**Notice of Decision
Town and Country Planning Act 1990
Town and Country Planning (Development
Management Procedure) (England) Order 2015
Approval of Permission for Development**

Application No: 6/2021/3198/HOUSE

Development: Erection of a single storey rear extension, alterations to fenestrations and existing balcony above extension

At Location: 55 The Ridgeway Cuffley Potters Bar EN6 4BD

Drawing Number FEB2022_55TRW_03	Rev A
------------------------------------	----------

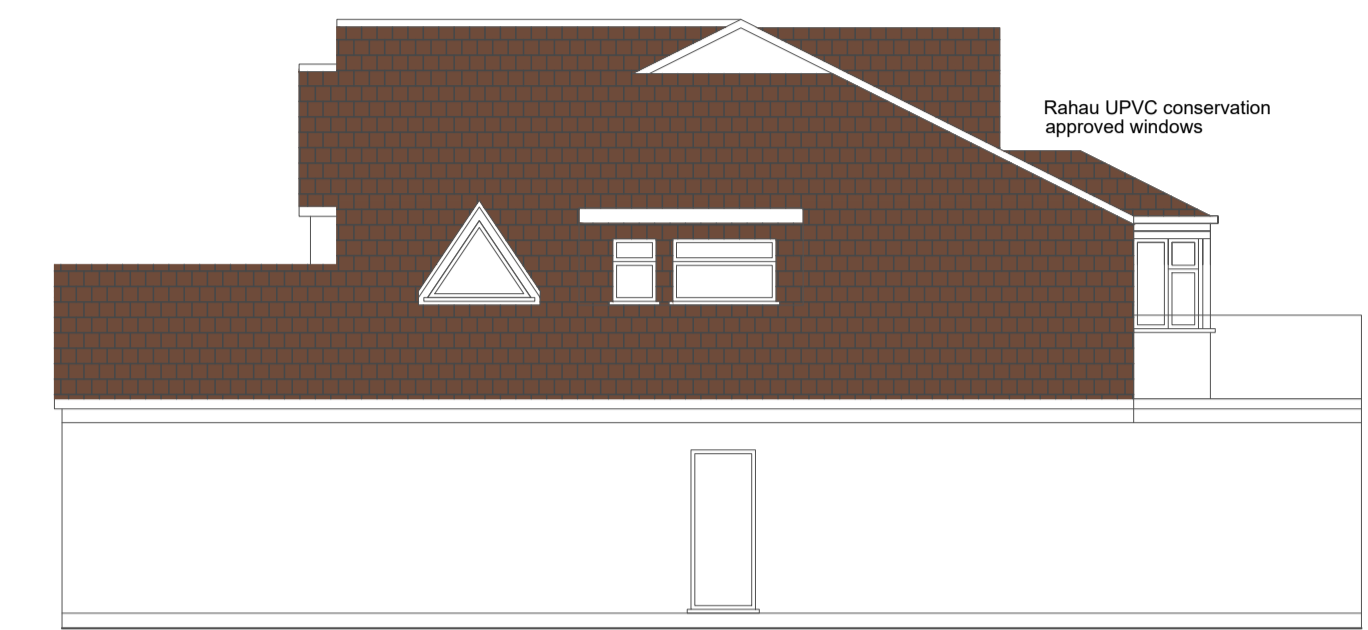
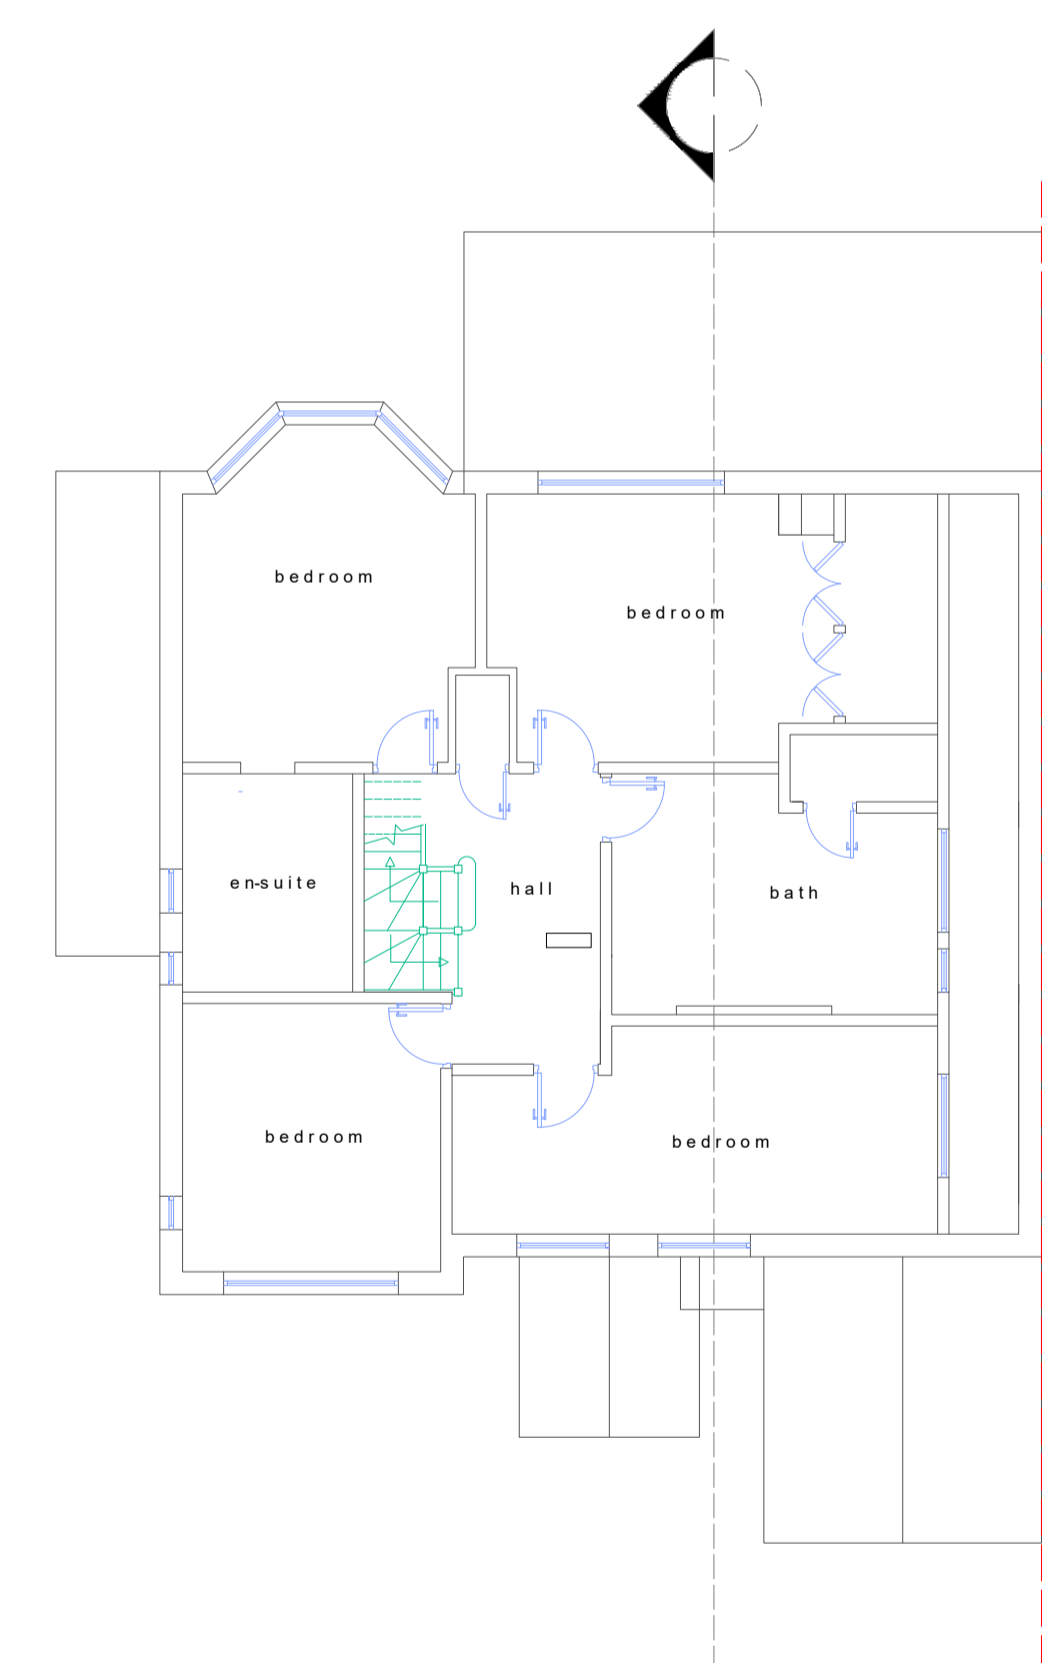
2. The first floor glazing panel of the balcony facing towards 57 The Ridgeway must be obscure-glazed and shall be retained in that form thereafter.
